Ribble Valley Borough Council
Planning Section
Council Offices
Church Walk
Clitheroe
BB7 2RA

Planning Application No: 3/2023/0685
Grid Ref: 377317 451496
Proposal: Proposed double garage.
Location: Broad Ings Anna Lane Bolton by Bowland BB7 4NZ

PROPOSED FLOOR PLAN

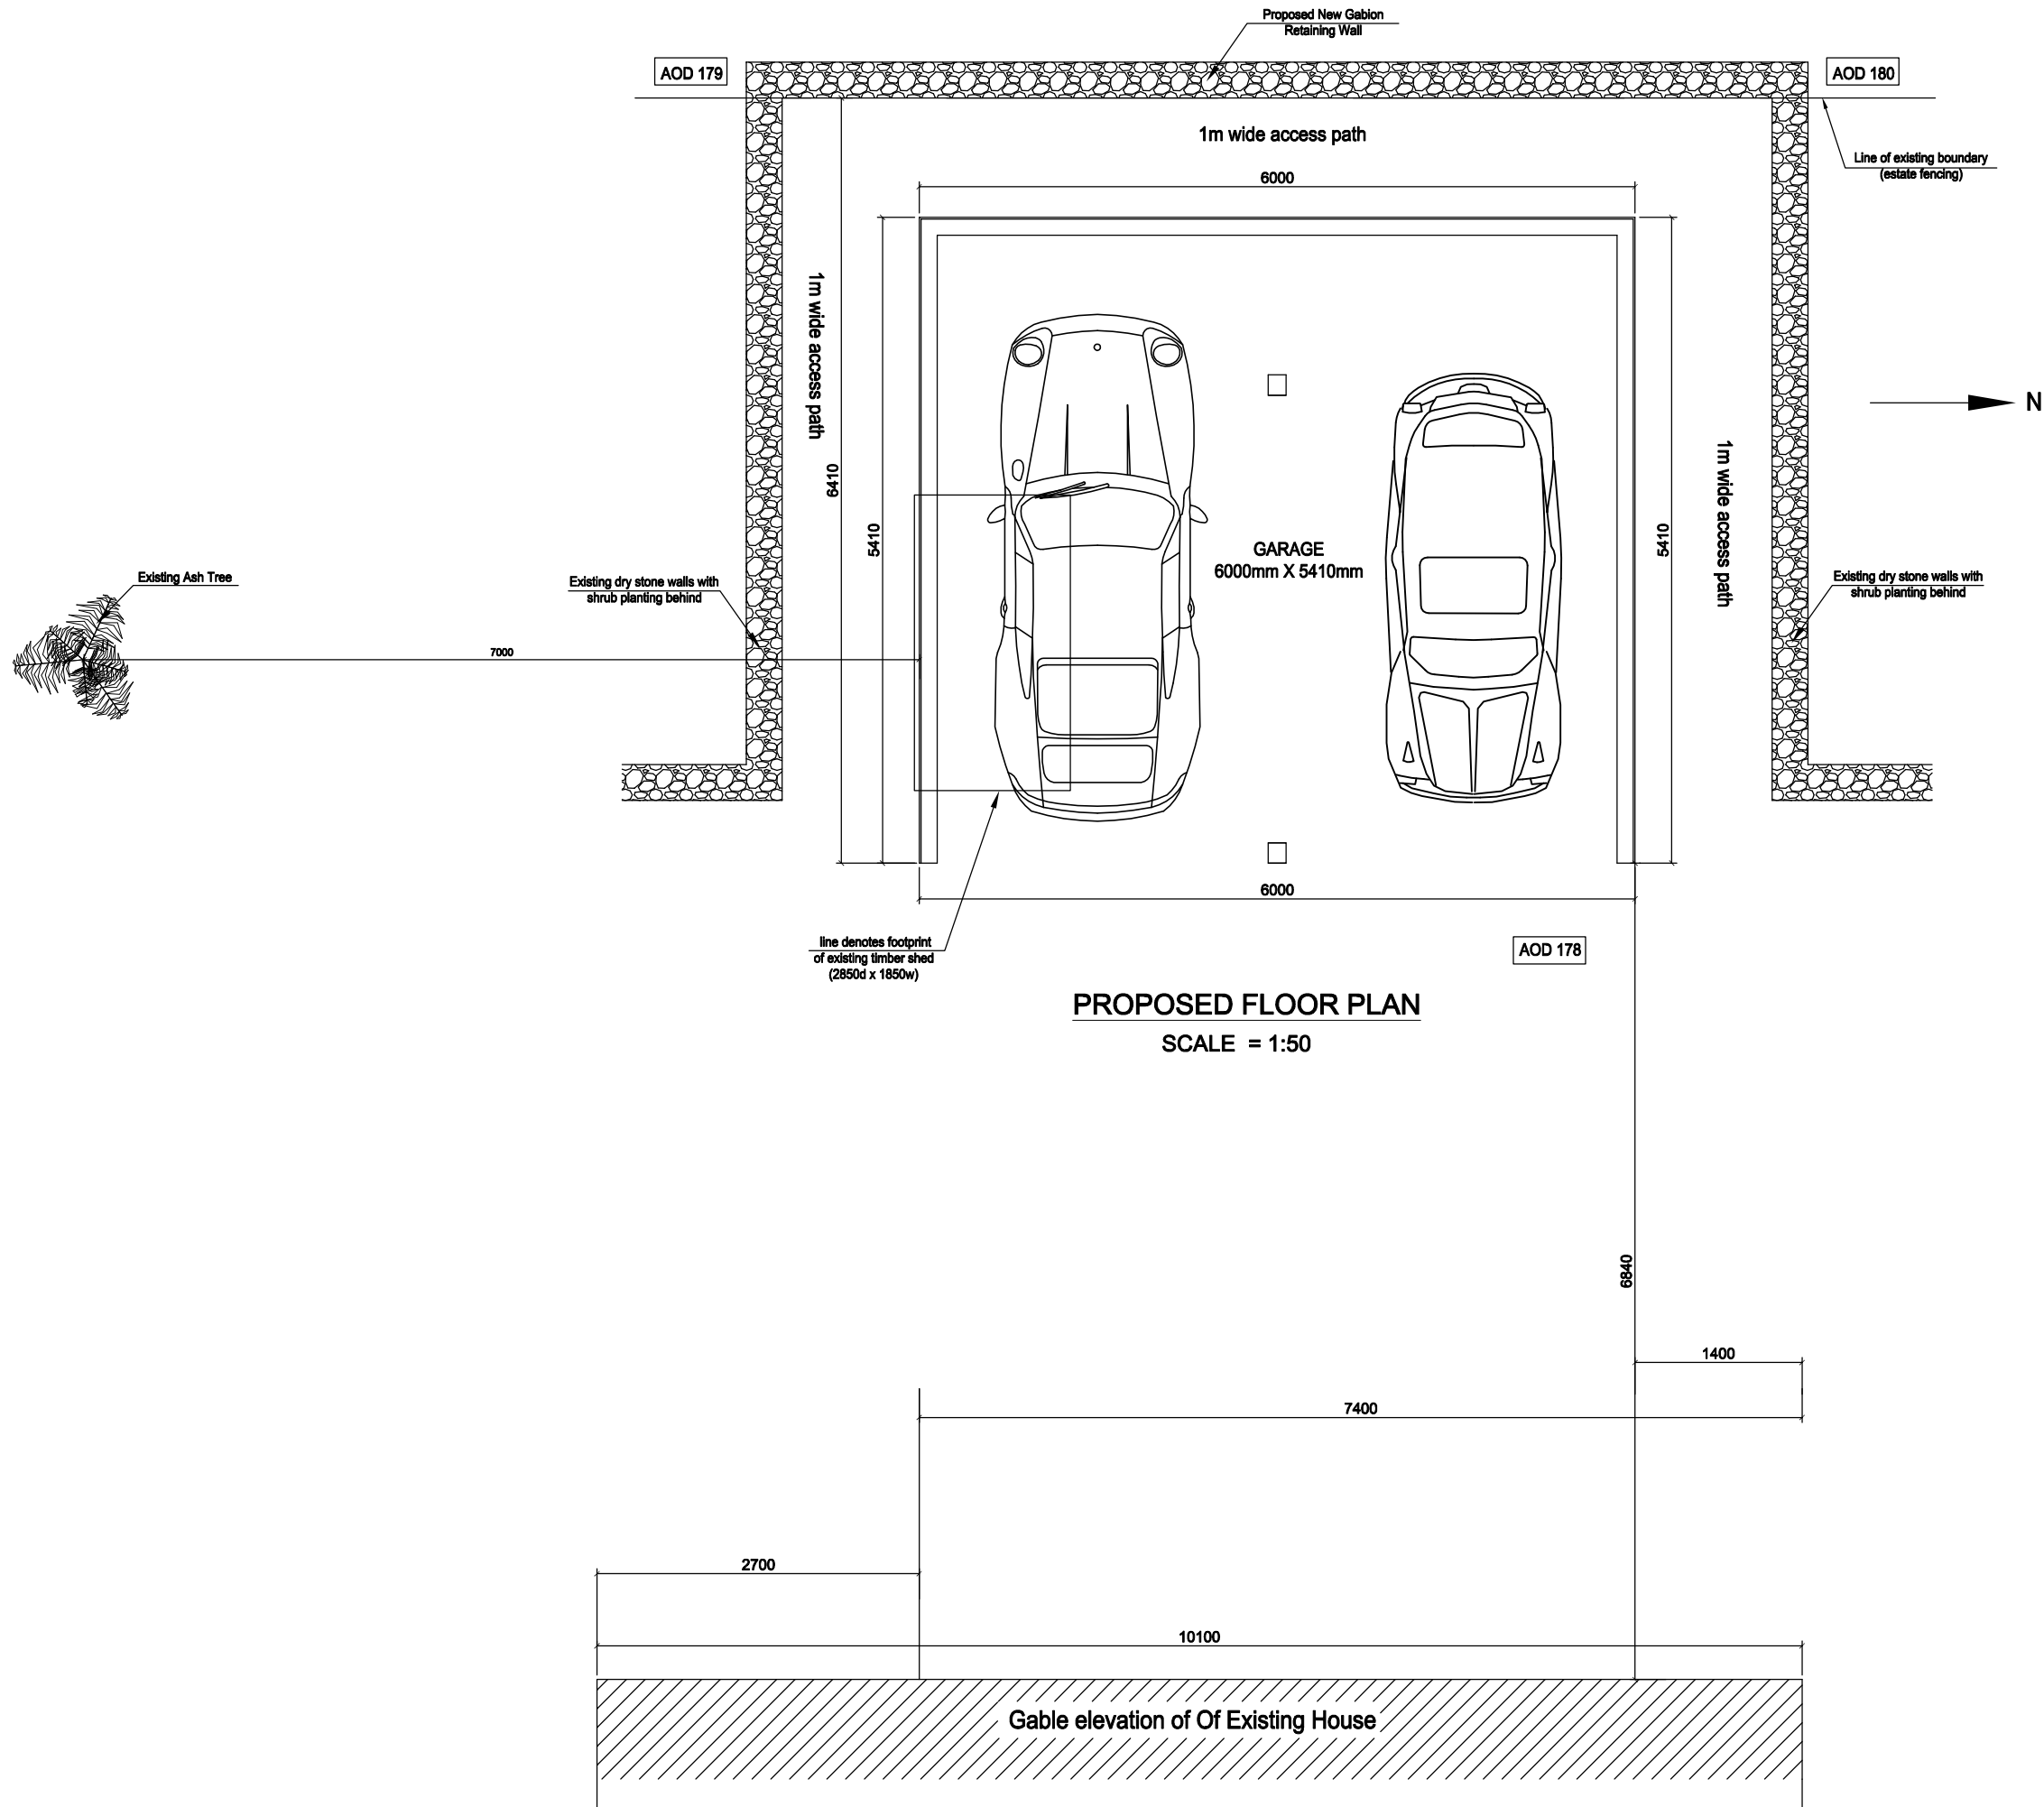
There is no objection to this proposal as an adequate level of off-road parking for the existing property will be retained. However, it must be noted, parking standards states that to be counted as 2 parking spaces, a double garage should be 6m x 6m. The garage is substandard (6m x 5.4m), therefore, this proposal would be counted as one parking space.
